From: Anita Gardner
Sent: 13 December 2018 11:05
To: Planning.Responses
Subject: FW: 125 Sea Road, East Preston EP/136/18/PL
Attachments: ITL12278-SK-013 Revised Tracking 1of2.pdf; ITL12278-SK-014. Revised tracking 2of2.pdf

You may be aware of objections expressed by some neighbours to our site at the above address, concerning our planning application for a minor material amendment to rearrange the car parking spaces within our site.

This is logged under Arun Planning Ref: EP/136/18/PL.

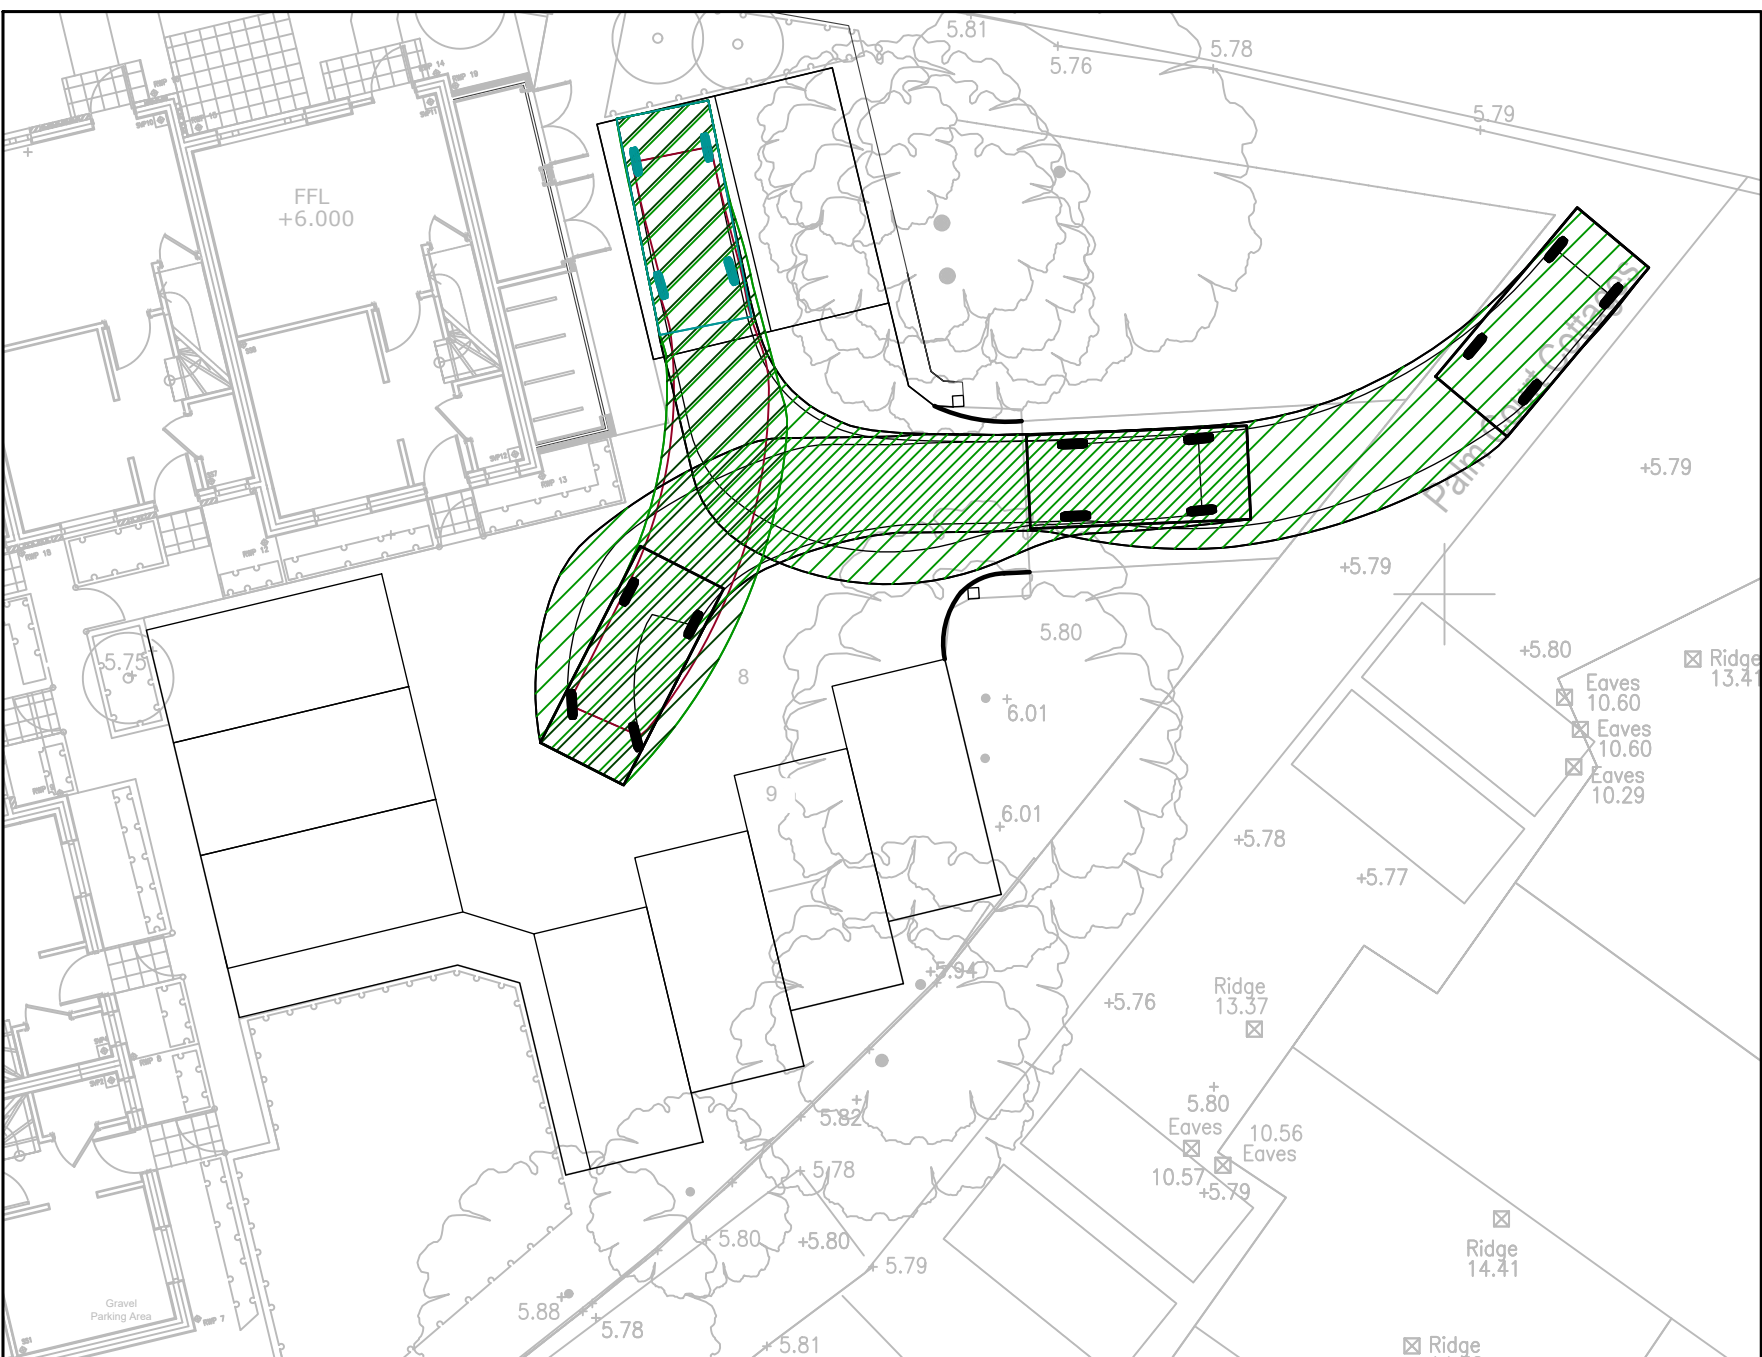
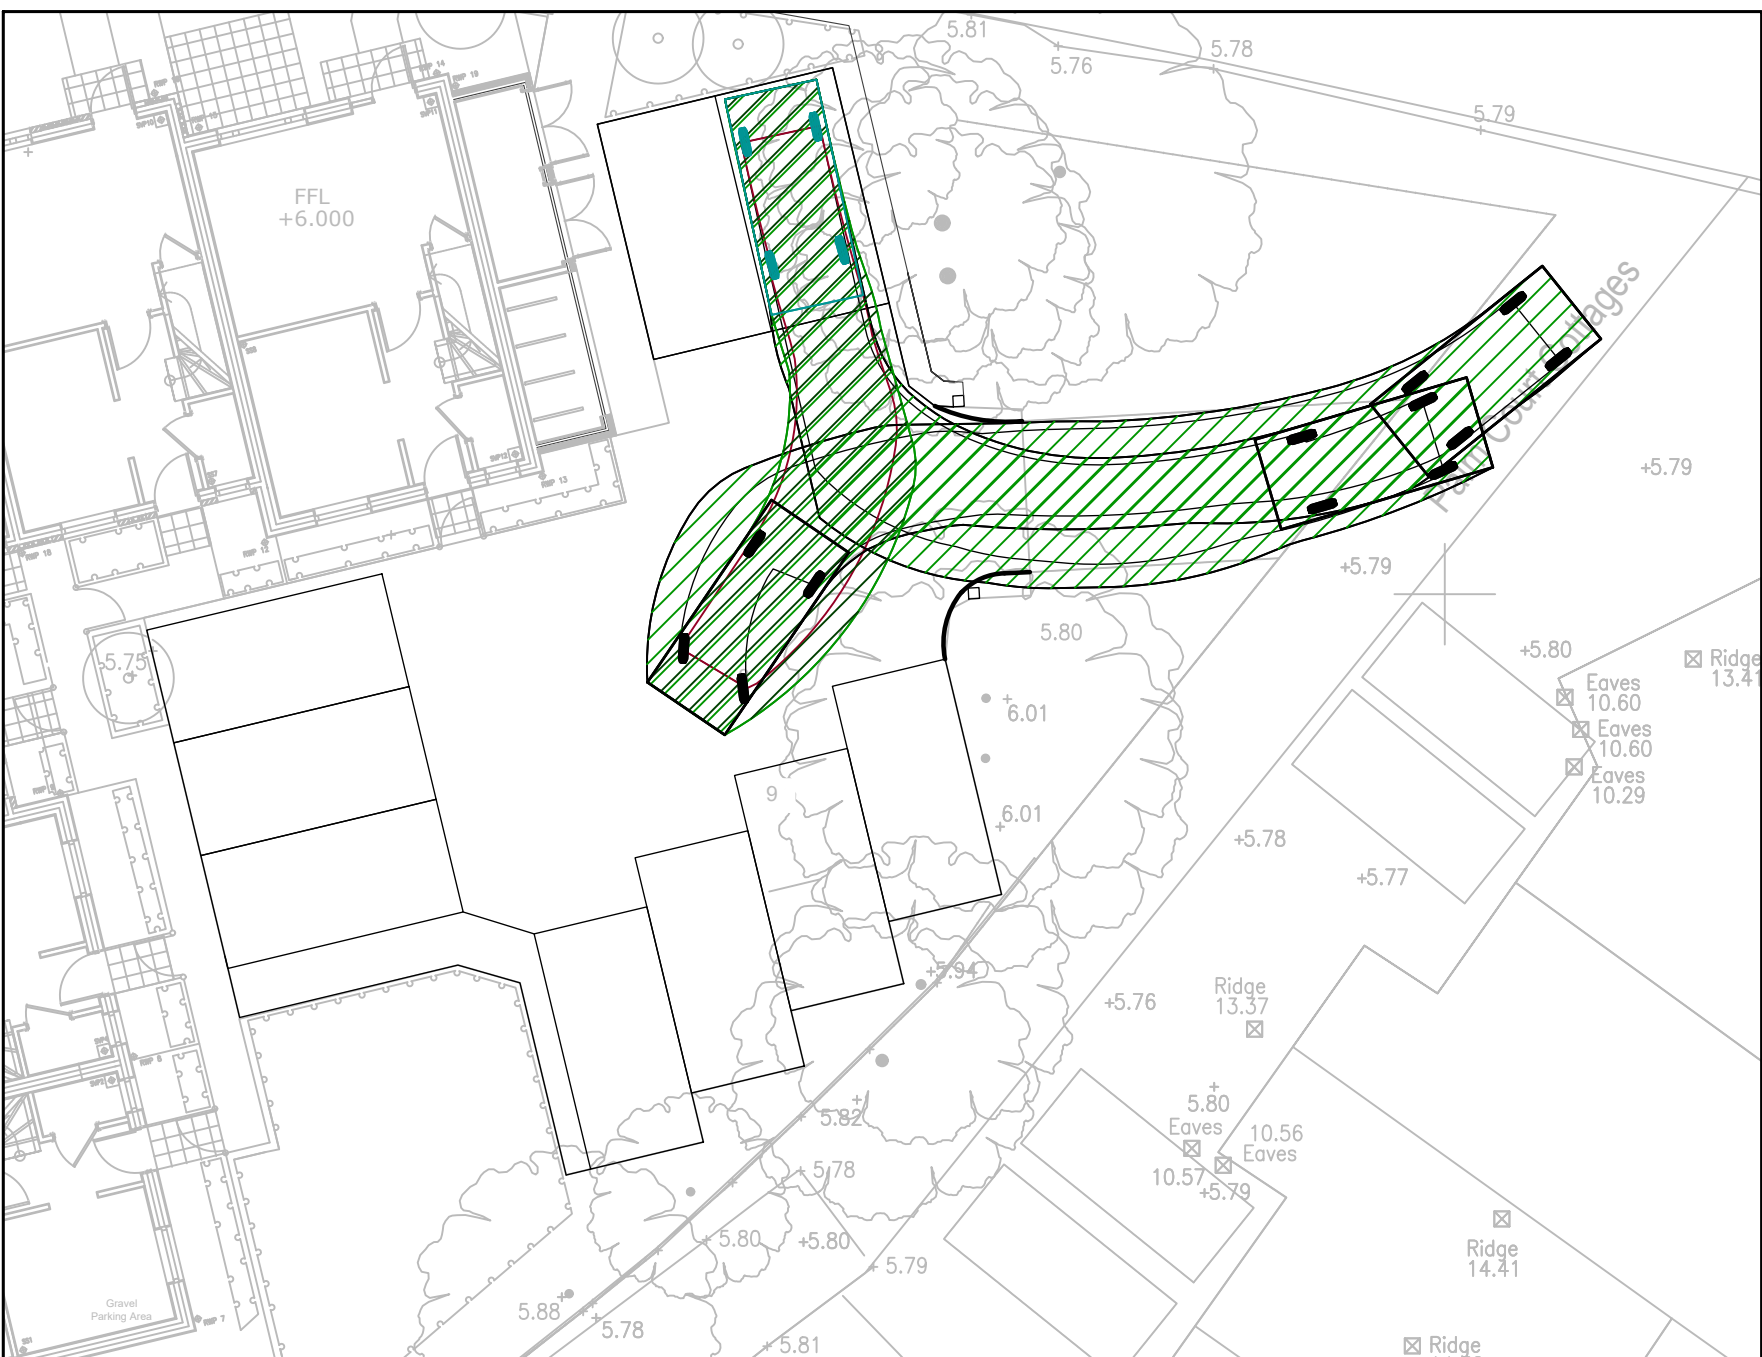
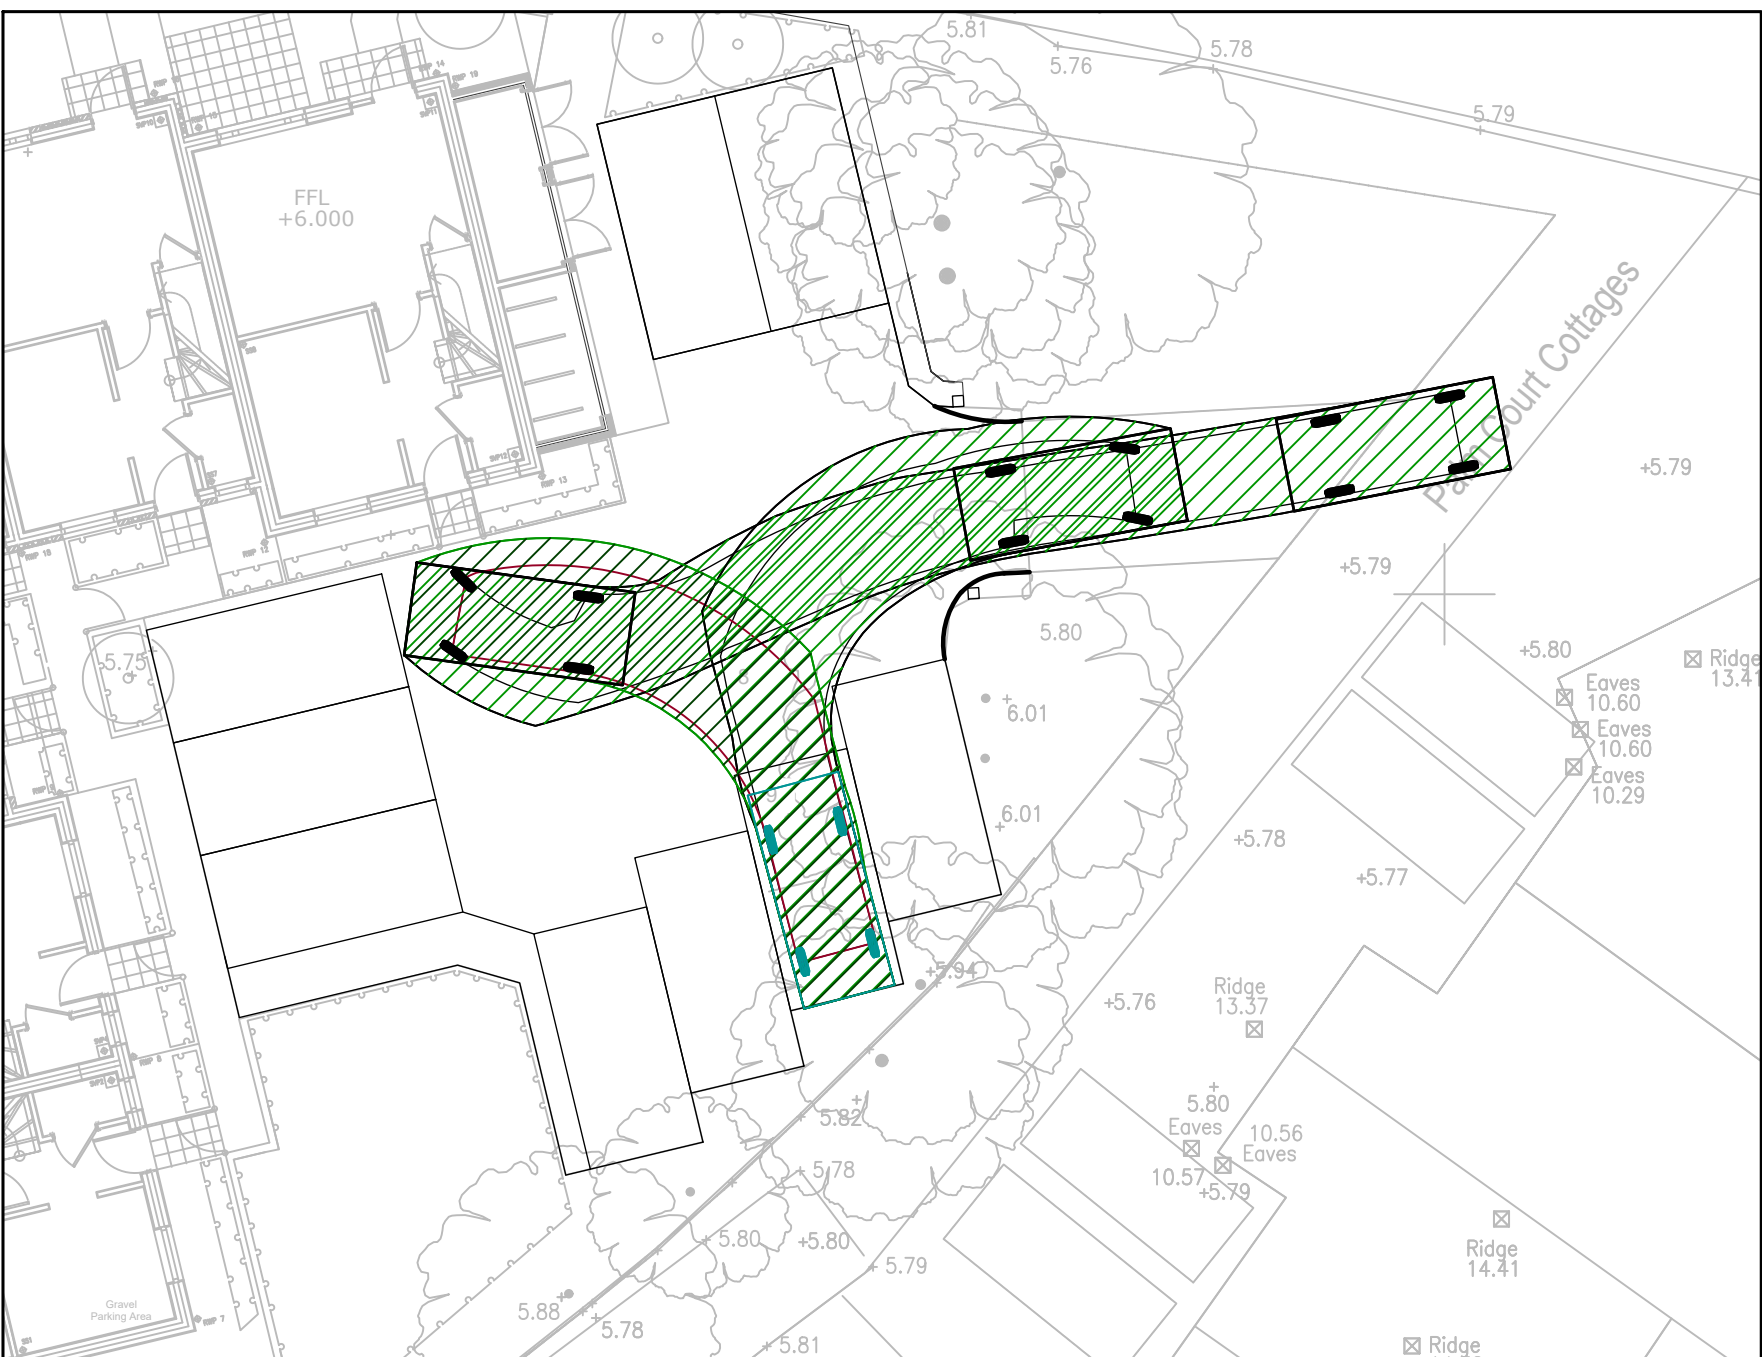
I have spoken with my Team Leader this morning and write to request that the Pringuer James drawing is updated to accord with the other later tracking plan. This will prevent potential confusion at Committee when there are essentially 2 different routes indicated. Will it be possible for this to be provided by lunchtime today? It is my intention to then refer to the later plan in the plans condition.

Ms. Risbridger's concerns centred around the angle of entry and exit from our site shown on the tracking drawings prepared by our engineers, Pringuer James (see attached) which were submitted with the application. She felt that the entry and exit route shown on those

drawings depicted vehicles coming too close to the terrace of Palm Court Cottages before turning north to South Strand.

If it would help, we can ask Pringuer James to amend their drawing to show this route of entry and exit and this proposed drawing could replace the earlier Pringuer James drawing - hopefully without having to re-consult - as this would be a very minor and non material amendment.
